Appeal Decision

Appeal Ref: APP/C3810/A/06/2021059

**1-3 Little Paddocks House, Little Paddocks Way, Ferring, Worthing, West Sussex
BN12 5NP**

- The appeal is made under section 78 of the Town and Country Planning Act 1990 against a refusal to grant outline planning permission.
- The appeal is made by Designer Developments Ltd against the decision of Arun District Council.
- The application Ref. FG/10/06, dated 9 February 2006, was refused by notice dated 10 May 2006.
- The development proposed is the demolition of 3 no. dwellings and replacement with 6 no. dwellings.

Client
DESIGNER DEVELOPMENTS LTDProject
RESIDENTIAL DEVELOPMENT AT
1-3 LITTLE PADDOCKS HOUSE, LITTLE PADDOCKS WAYDrawing
SITE LAYOUTDate
JAN 06Scale
1:500Drawn
EYChecked
Drawing No
4861/9K2B Red line extended 21-03-06
A Pbt 3 revised 08-02-06Revision
A B

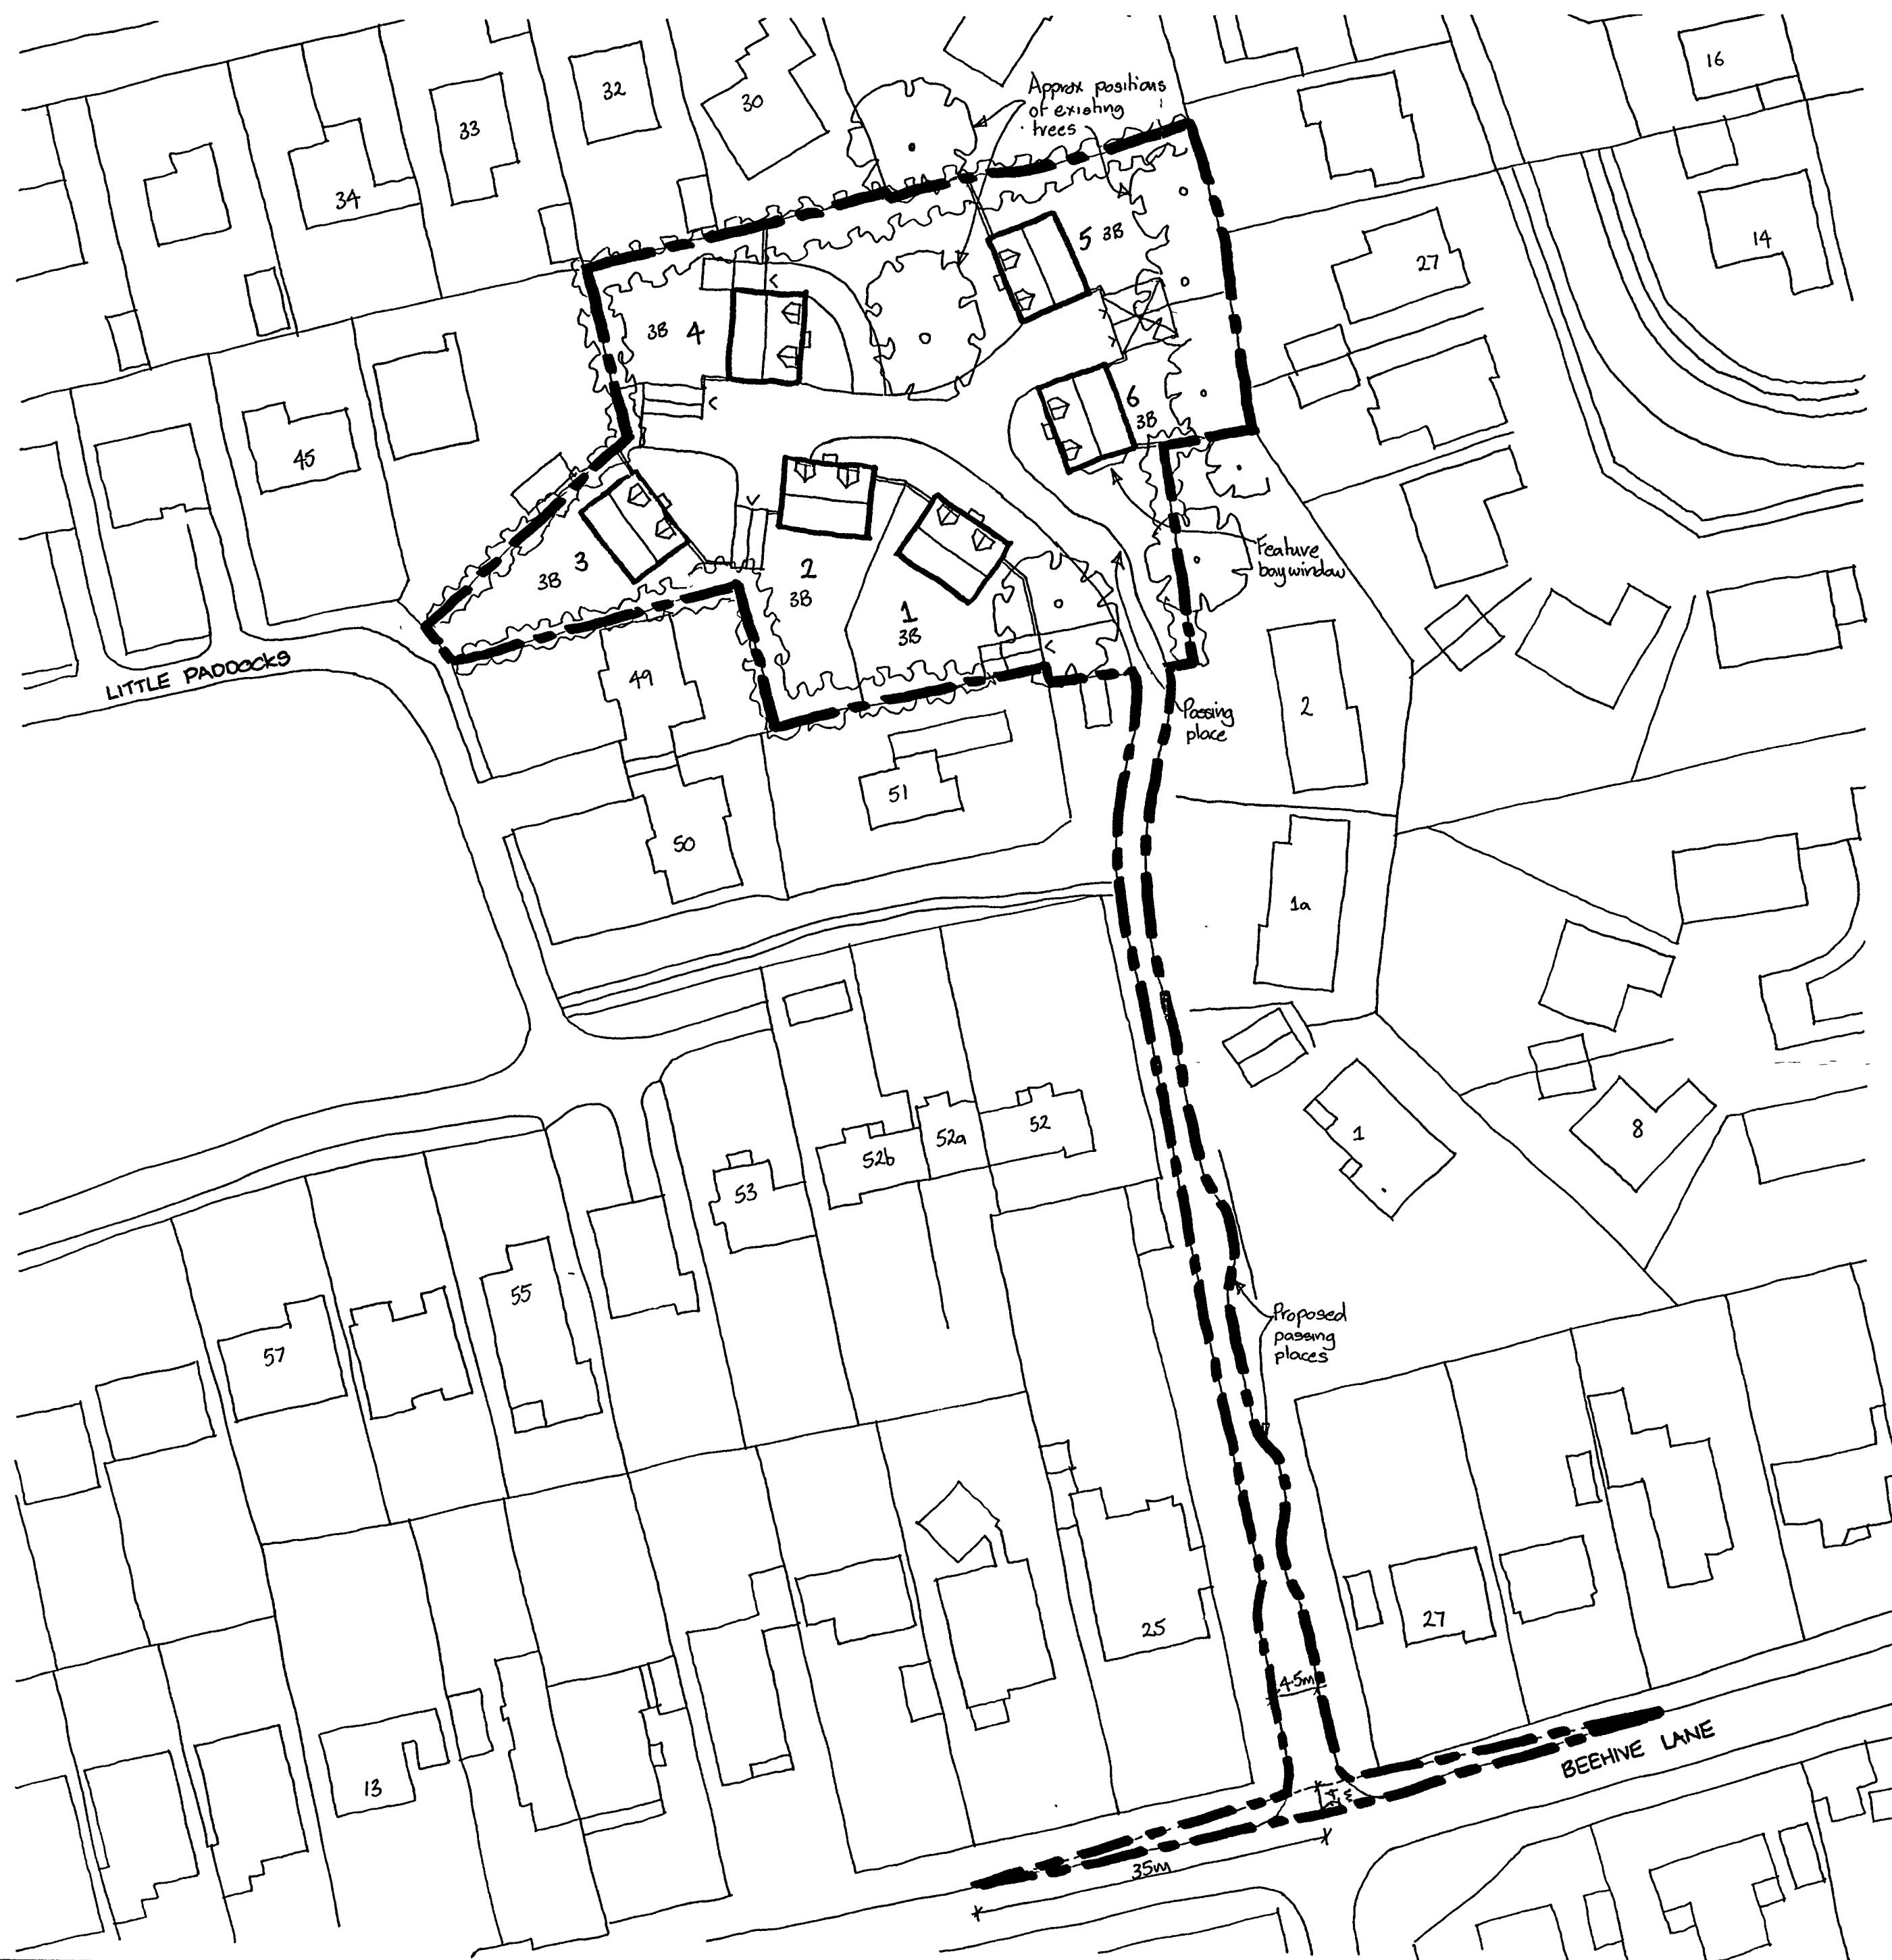
5. In my opinion, there is sufficient space to accommodate the bungalows without compromising normal site planning considerations, taking into account privacy, light and outlook, subject to the detailed design of the dwellings. Extensive vegetation around the boundaries of the site would retain the feeling of self-containment, although there would be some partial views into the site from various directions. I regard the relationship between

- the dwelling on plot 3 and nearby properties in Little Paddocks as being acceptable. The illustrative layout shows how dormer windows could be restricted to the front elevation. That would be a matter for consideration when details were submitted for approval.
